CONFERENCE RECAP

DRAINAGE FILE/ZONE, LAST PAGE NO.: J-21 DATE: 11/20/85  
PLANNING DIVISION NOS. EPC: \_\_\_\_\_ DRB: \_\_\_\_\_  
SUBJECT: Hairstressing Salon  
STREET ADDRESS (IF KNOWN): \_\_\_\_\_  
SUBDIVISION NAME: Lot 13-B-2, Blk 10-A Princess Jean Park

RE: DRAINAGE PLAN FOR TIM CHAVEZ HAIRDRESSING SALON  
RECEIVED JANUARY 10, 1986 (J-21/D22)

GRADING AND DRAINAGE PLAN
FOR
TIM CHAVEZ - HAIRDRESSING SALON
EUBANK BOULEVARD, N.E.
ALBUQUERQUE, NEW MEXICO
JANUARY, 1986

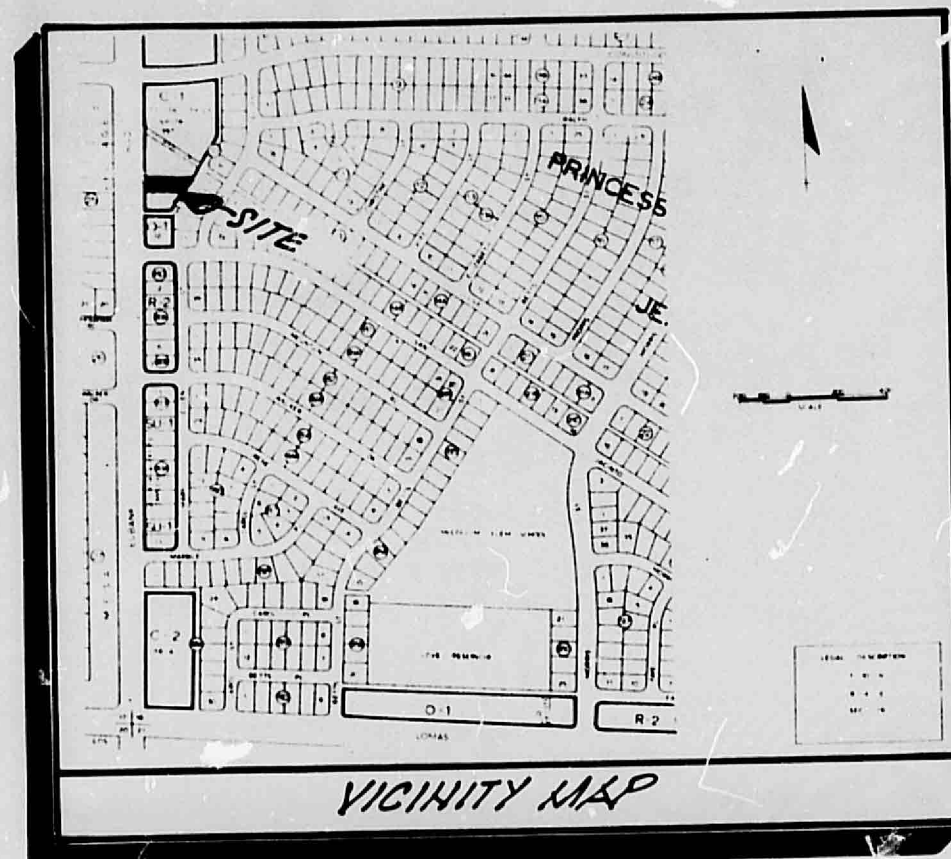
- ① Discharge rate from the site is to be determined by analysis of downstream capacity and/or impact from proposed development.
- ② City approved alley grades are required for the abutting improved alley. The grades will be waived until issuance of C.D. The waiver is based on non-usage of the alley for access or drainage purposes. On-site development is to indicate a buffer area for fluctuation of the approved grades.
- ③ An erosion control plan to ensure sediments remain on-site during construction is required.

- 1 small site
- 2 runoff insignif. on street -
- 3 will enter catchb. Downstr. quickly  
will not contribute to Downstr. flood
- 4 alley grades. - cannot use for access  
or discharge - have landsc. area to  
give buffer bet. alley & lot paving.
- 5 Run through landsc. to show runoff
- 6 Temp sediment pond @ landsc. to  
keep silt out of R.O.W.

Please be advised that the Certificate of Occupancy is contingent upon receipt of a copy of the approved alley grades for our files.
